Planning Application No: BE/17/18/PL

F.A.O Case officer Mr S. Davis, Arun District Council. Planning Department.

Whilst I appreciate that Norbren Avenue and Greencourt Drive are located within the 20mph speed zone I feel the following points are still valid relating to the proposed property to be located immediately adjacent to the junction of Norbren Avenue and Greencourt Drive. Excessive on-street parking can affect the safety of pedestrians, cyclists as well as drivers of vehicles and in some cases lead to disputes between neighbours.

Proposed Ground Floor Plan

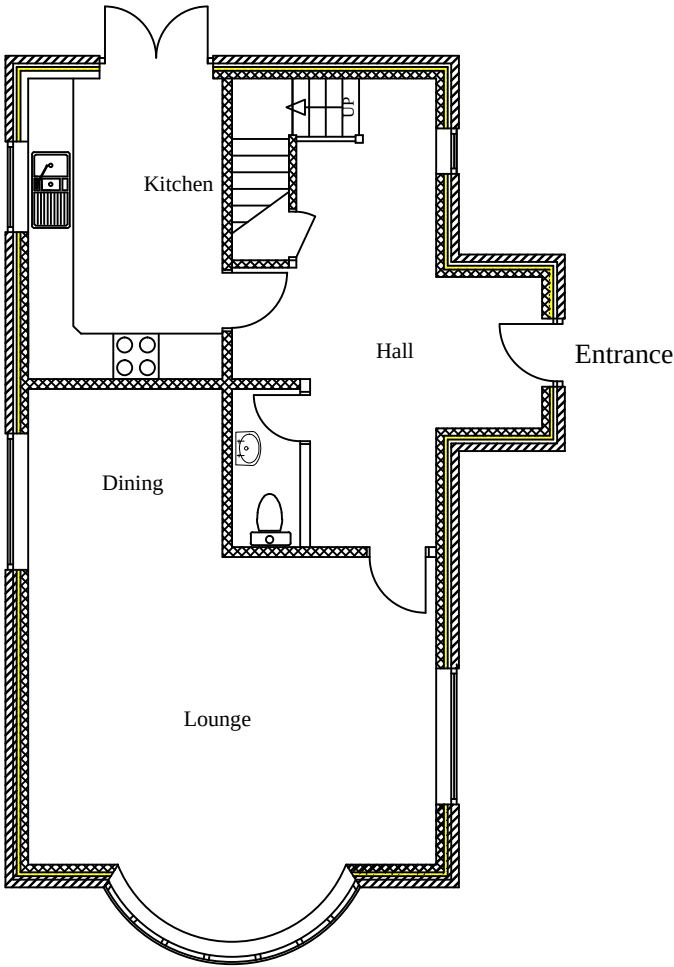
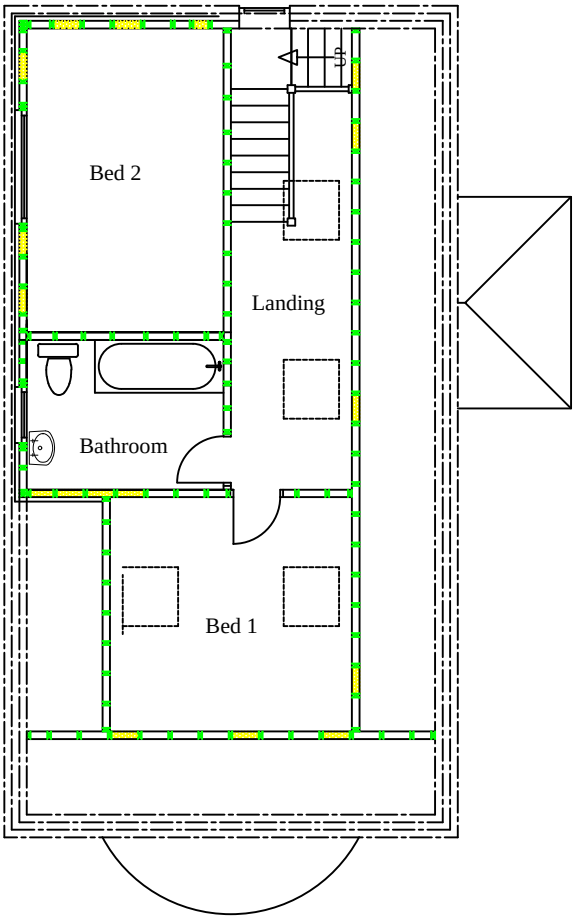
1. Existing on-street parking immediately to the east of the proposed property will impair visibility of any vehicle leaving and entering the proposed property's driveway.
2. The extra potential for on-street parking at the road junction of Norbren Avenue and Greencourt Drive due to the proposed property will further exasperate the use of the junction because of:
 - a. Poor visibility of vehicles exiting Norbren Avenue into Greencourt Drive.
 - b. Narrowing Norbren Avenue next to its junction with Greencourt Drive thus making access and egress for vehicles entering or leaving Norbren Avenue from Greencourt Drive difficult.
 - c. The extra parking will only make the already awkward manoeuvring for vehicles entering and leaving the drives, for all properties in the immediate vicinity, a lot worse.
